COUNTY COUNCIL'S RESPONSE TO CONSULTATION ON THE FOLLOWING DEVELOPMENT PROPOSAL

Application No: 19/01740/HYBRID

Proposal: This application comprises a 'hybrid' planning application comprising: - Outline planning permission (all matters reserved except for access) for up to 23,400sq.m of B1 development (Use Classes B1a and/or B1b and/or B1c); highway works (including provision of a new roundabout at the junction between Vendee Drive and Wendlebury Road); creation of a wetland and landscaped areas; and associated infrastructure works. - Full planning permission for a health and racquets club, associated access and car parking, outdoor tennis courts, air dome, outdoor swimming pool, spa garden and terrace, and associated landscaping.

Response date: *23rd October 2019*

JOB TITLE		CLIENT	
CATALYST BICESTER		ALBION LAND	
DRAWING TITLE			
WENDLEBURY ROAD FOOT/CYCLEPATH ENHANCEMENT WITH HEALTH AND RACQUETS CLUB			
SCALE	DRAWN BY	DATE	DRAWING No
1: 500@A1	RJM	03/05/19	19539-12-01
			REVISION
			B

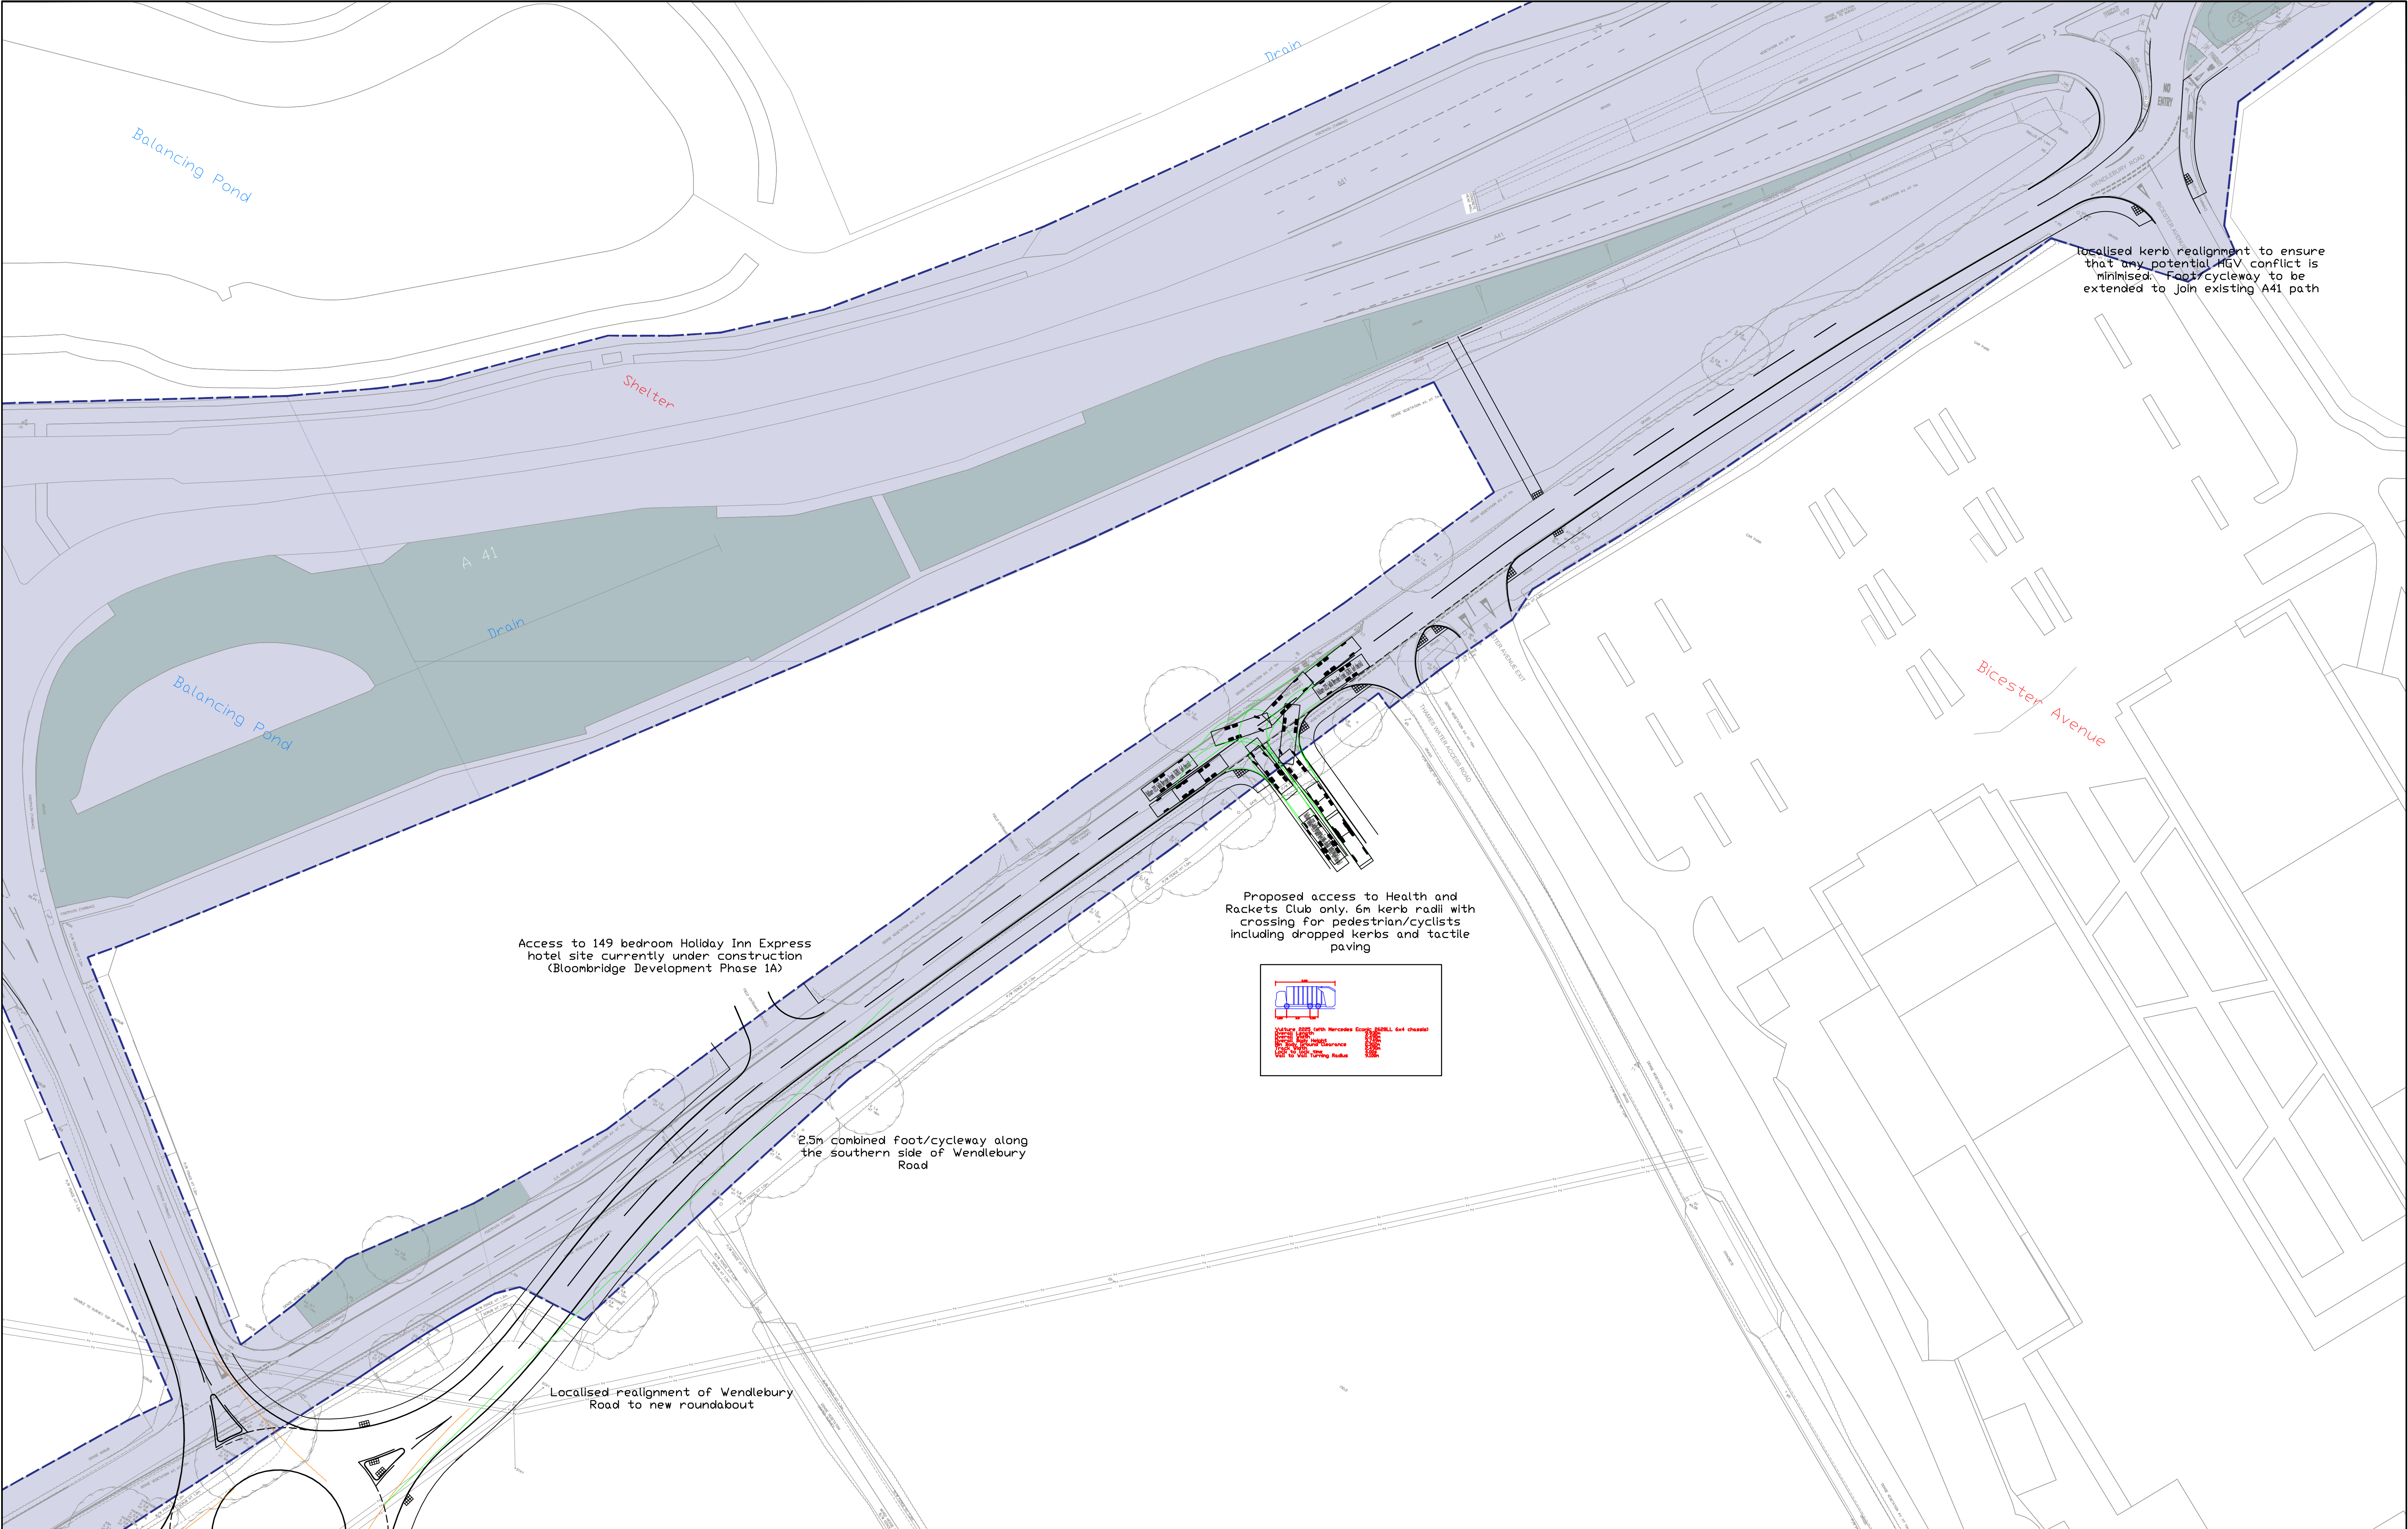
Wendlebury Road is a Sustrans cycle route (NCN51) without a dedicated cycleway in the vicinity of the site. The development here intends to provide a shared use facility for both cyclists and pedestrians (illustrated by Drawing No. 19539-13-01 Rev A) along the southern side of Wendlebury Road. Whilst this provision is welcomed, the 2.5m wide facility is however questioned especially where a significant amount of two-way cycling is expected. A width of 3m should generally be regarded as the preferred minimum on an unsegregated route, although in areas with contraflow cycling a wider facility should suffice.

This section of Wendlebury Road benefits from sufficient highway verges on both sides. For purposes of maintaining the standard footway/cycleway facilities, the applicant may explore widening of the carriageway given the resulting increase in traffic due to this development. This would in turn address Problem 1.01 as identified by the independent Road Safety Audit undertaken by Mott MacDonald.

JOB TITLE CATALYST BICESTER		CLIENT ALBION LAND	
DRAWING TITLE WENDLEBURY ROAD SITE ACCESS ROUNDABOUT			
SCALE 1: 500@A1	DRAWN BY RJM	DATE 03/05/19	DRAWING No 19539-12-02
REVISION B

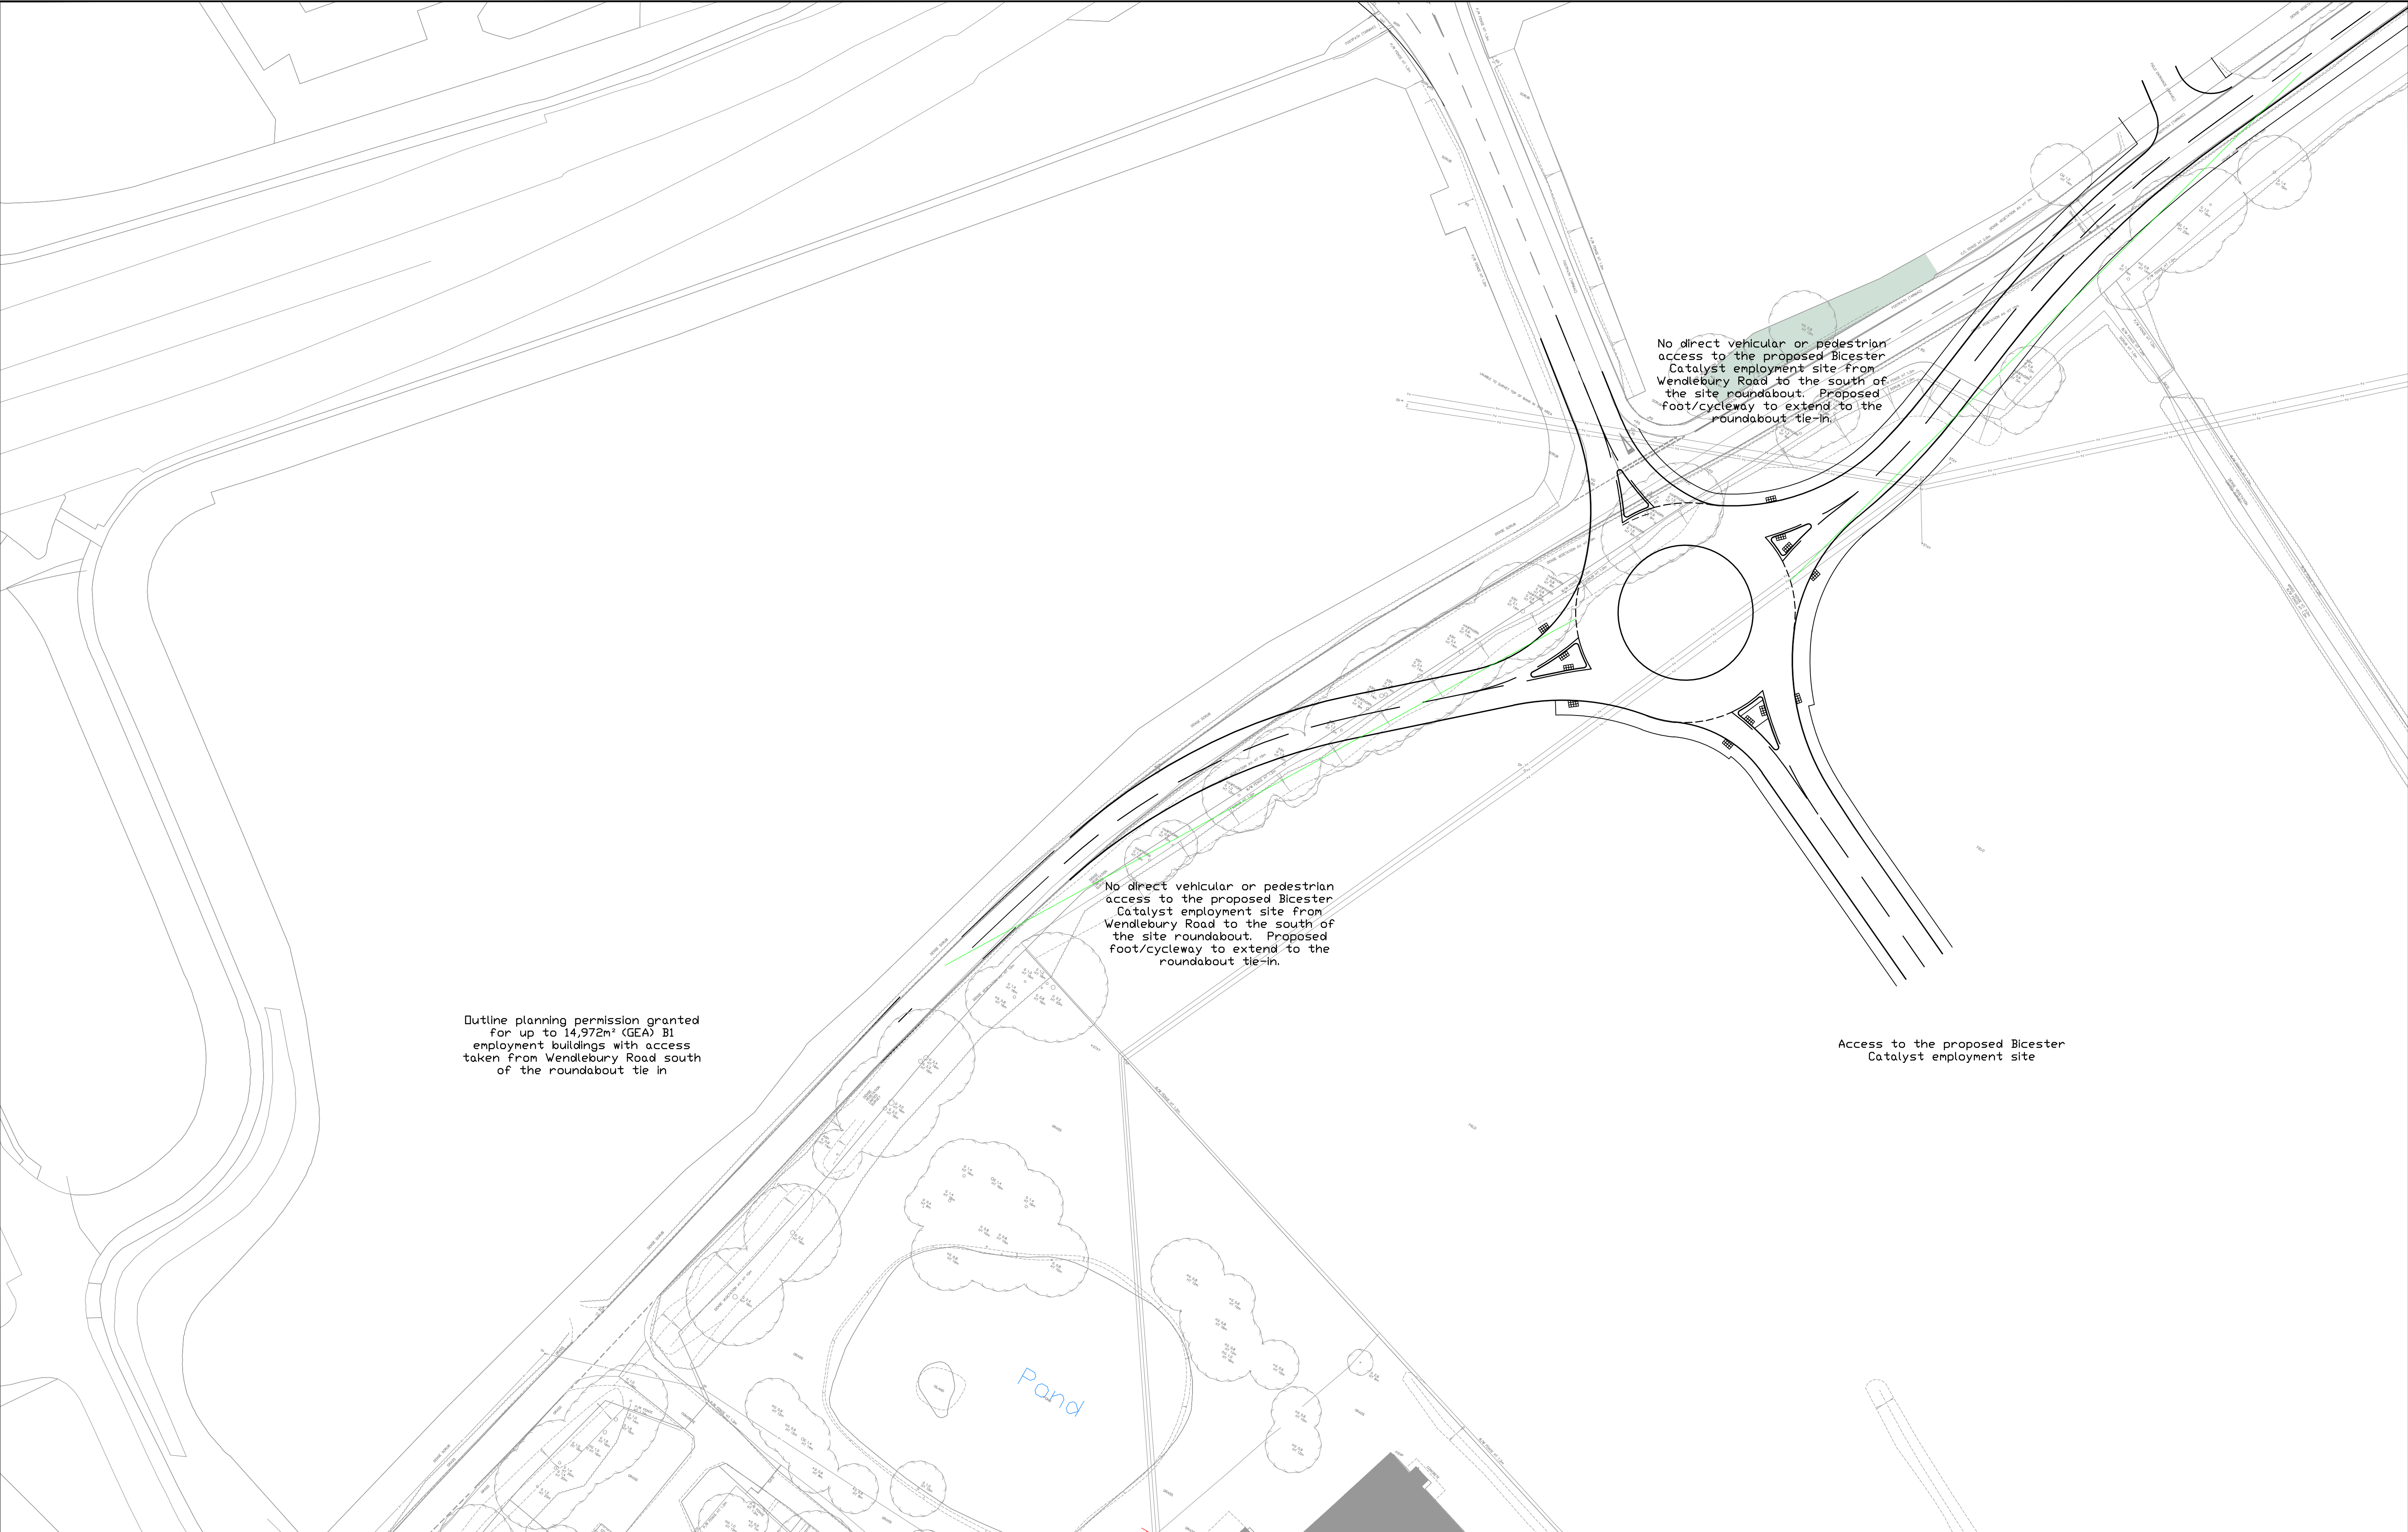
The application claims to improve cycling provision. Paragraph 5.1.2 states that, *“where the foot-cycleway crosses the accesses to the Thames Water site and Bicester Avenue appropriate crossing details will be provided including dropped kerbs, tactile paving and appropriate signage.”* Drawing No. 19539-11-01 Rev A appended to the TA illustrates the intended arrangement of the foot-cycleway crossings. OCC do not approve of the proposed crossings and instead require that raised table treatments are utilised to create a more convenient and safer environment that prioritises non car travel. This should also include the health club access.

On a separate drawing, (Drawing No. 19539-11-02 Rev A) the termination of the shared use facility raises safety concern particularly for southbound cyclists and/ or pedestrians running past the roundabout towards Wendlebury. These shall be forced to abruptly re-join the carriageway while still within the roundabout envelope – which is not considered safe. It is thus recommended that termination of this shared use facility should extend a safe distance away from the roundabout (as shown in the RSA Stage1 report) for the entire frontage of the development, west of the access. This is partly due to the changing character of Wendlebury Road to an urban form.
